Re: Marysville Corporate Center BSP – *Final Review 2*
PA22004

After reviewing the revised Final Binding Site Plan (BSP) application materials for the above referenced proposal, the following technical review comments are provided below.

FINAL BSP Amendments

TITLE REPORT ITEM NOTES:

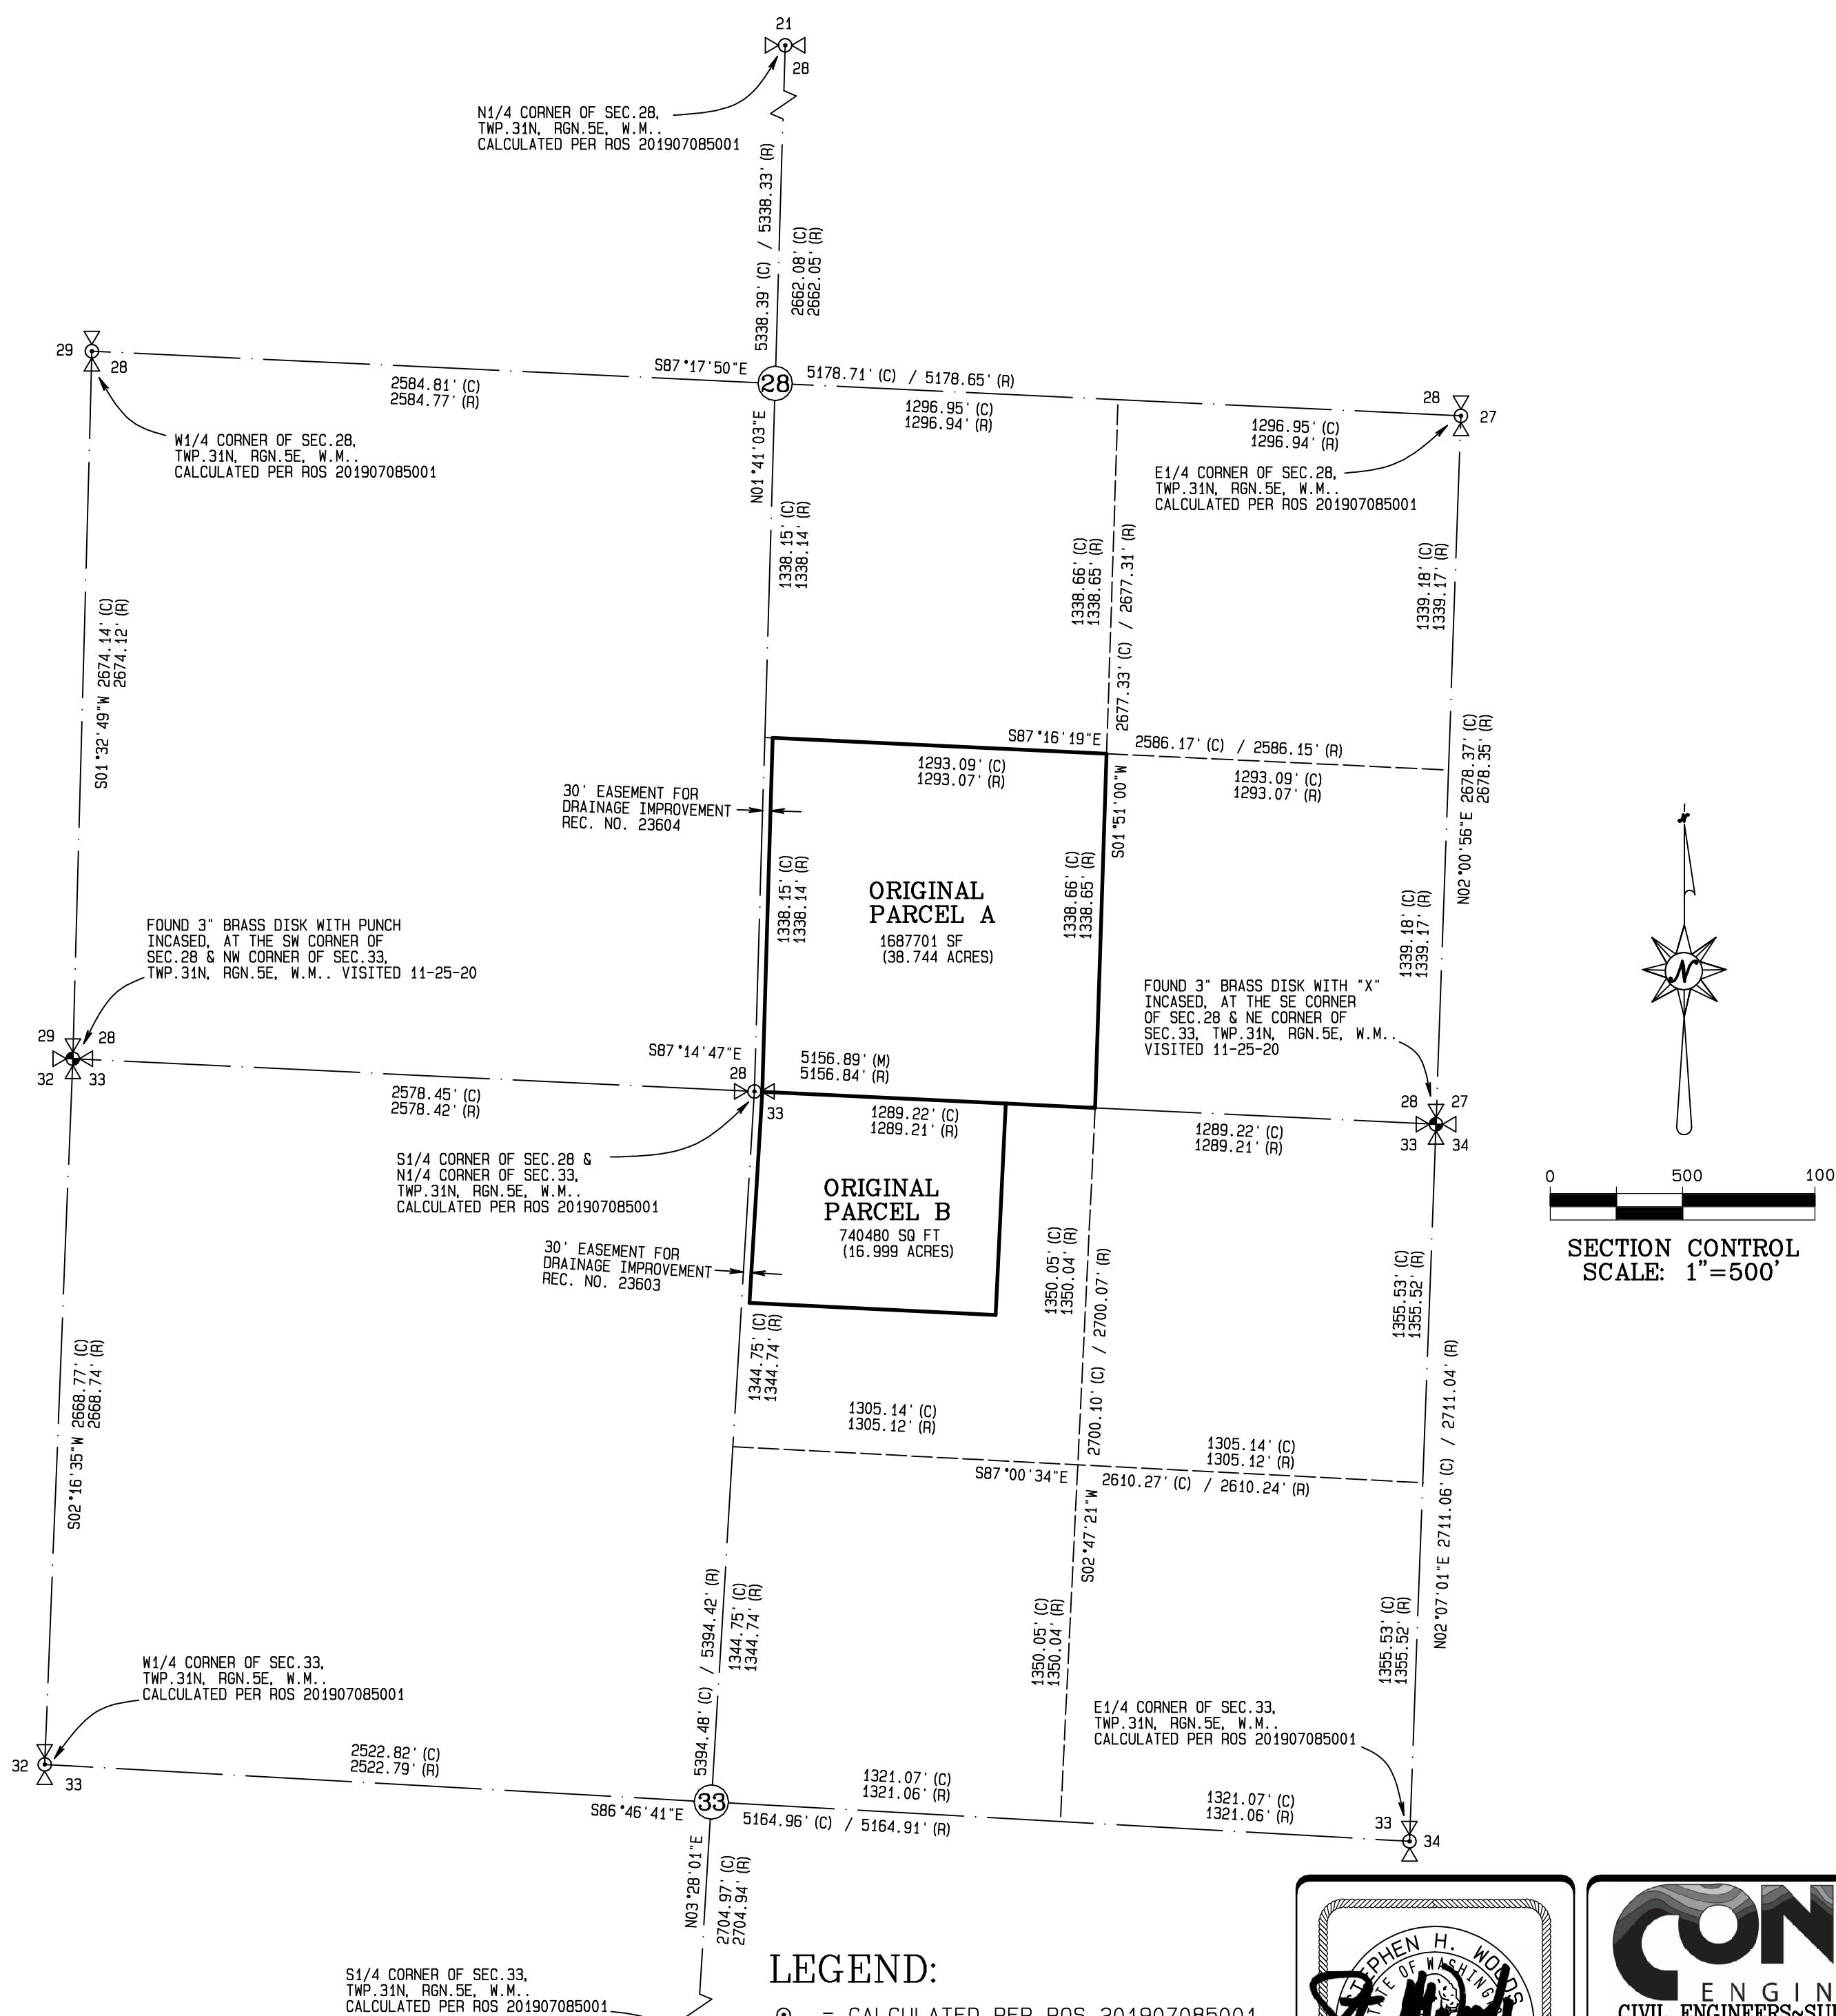
2. Sheet 2 of 9: TITLE REPORT ITEM NOTES No. 10, Add AFN 202402010260
3. Sheet 6 of 9: Remove CARPOOL PARKING SIGN exhibit and language.
4. Sheet 7 of 9: Remove the swale from Lot 4. Only the lot lines should be shown.
